Re: THE SHOPS AT PASEO & COORS
9370 COORS BLVD. NW
Approval of Permanent Certificate of Occupancy (C.O.)
Engineer's Stamp dated 03/17/2004 (C-13/D025C)
Certification dated 07/21/2004

Re: The Shops at Paseo and Coors, 9370 Coors Blvd NW, Grading and Drainage Plan

The purpose of this letter is to address the comments made by you regarding the Grading and Drainage Plan for The Shops at Paseo and Coors development dated January 9, 2004.

Re: The Shops at Paseo and Coors, Site Development Plan
Engineer's Stamp dated 1-09-04 (C13/D25C)

SHEET  
**SDP-2**

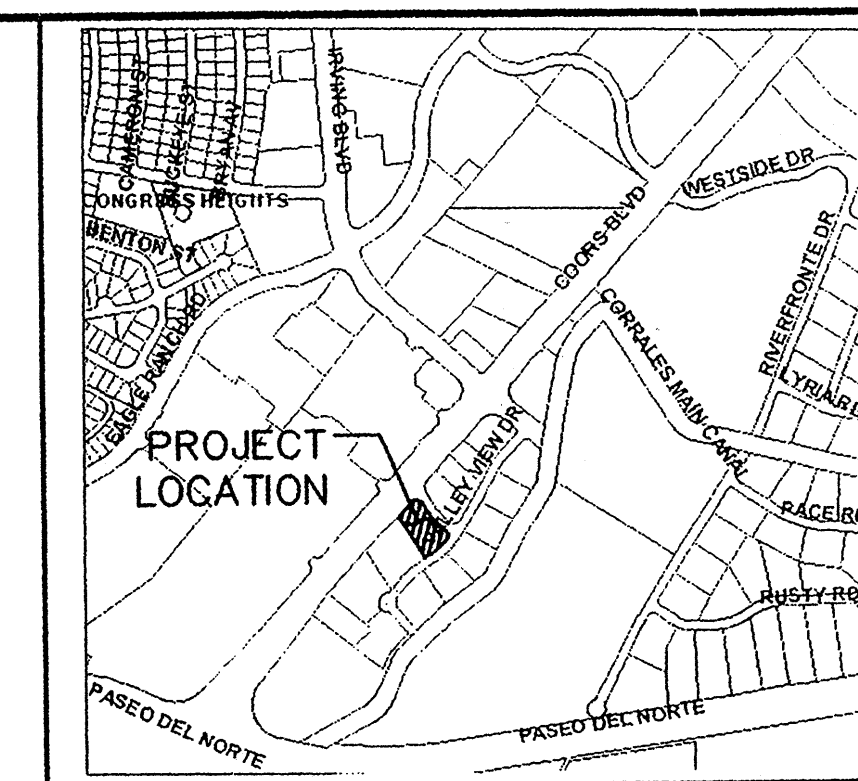
1. Please show a vicinity map.
2. What is the width of the proposed sidewalk? Note that the 2 foot overhang is not allowed to encroach on the 6 foot required width of sidewalk.
3. List the number of parking spaces required by the zoning code as well as the proposed number of parking spaces.
4. The handicapped spaces must be a minimum of 8.5 feet in width.

## GRADING, DRAINAGE & UTILITY PLAN

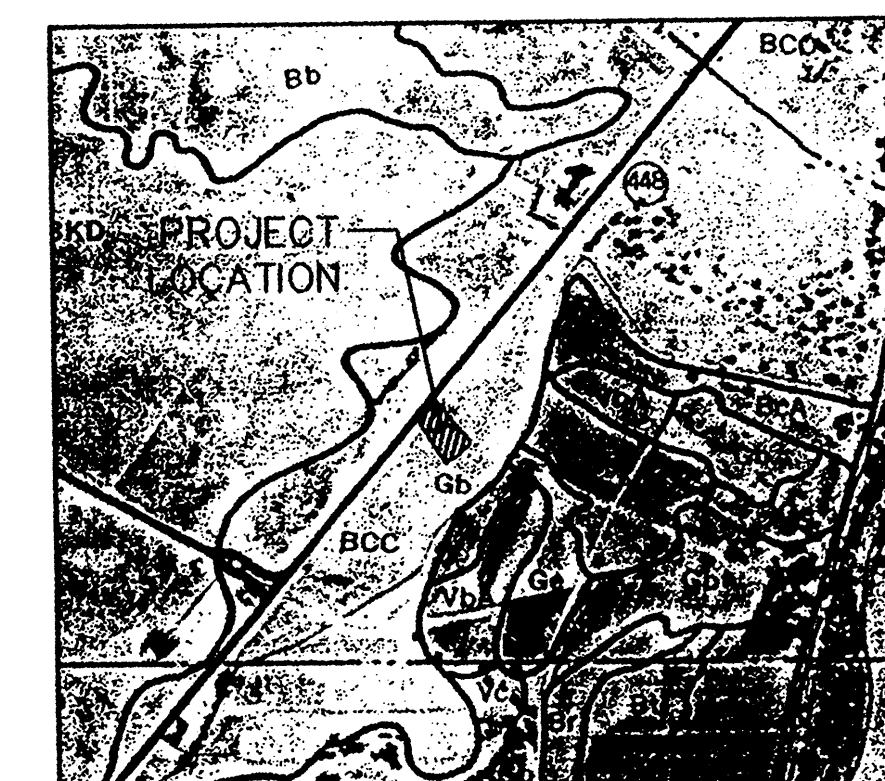
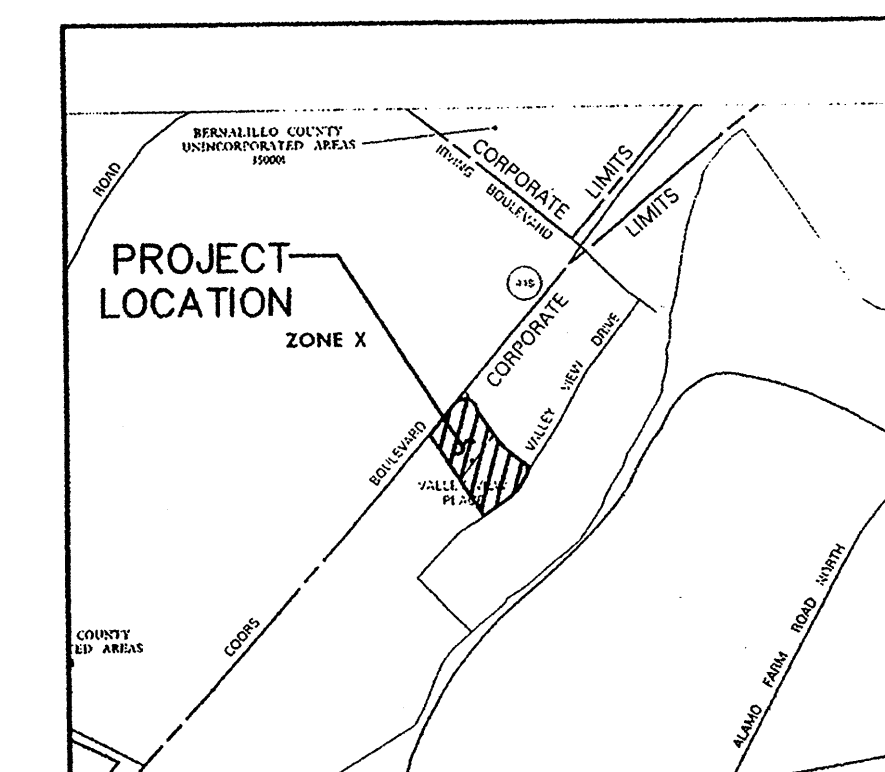
Comment 2: It is unclear whether flow from this site enters the site to the southwest via the shared drive. Please show more detail in this area.

1. List the address of the site.
2. It is unclear whether flow from this site enters the site to the southwest via the shared drive. Please show more detail in this area.
3. Call out the tract numbers of the adjacent sites.

Solution: As per the approved drainage master plan, drainage from this area enters the site to the southwest and drains into the storm drain system along Valley View Drive. The covenant for the site allows for shared flow for the area. Additional elevation points have been added to the plan to show this in more detail.
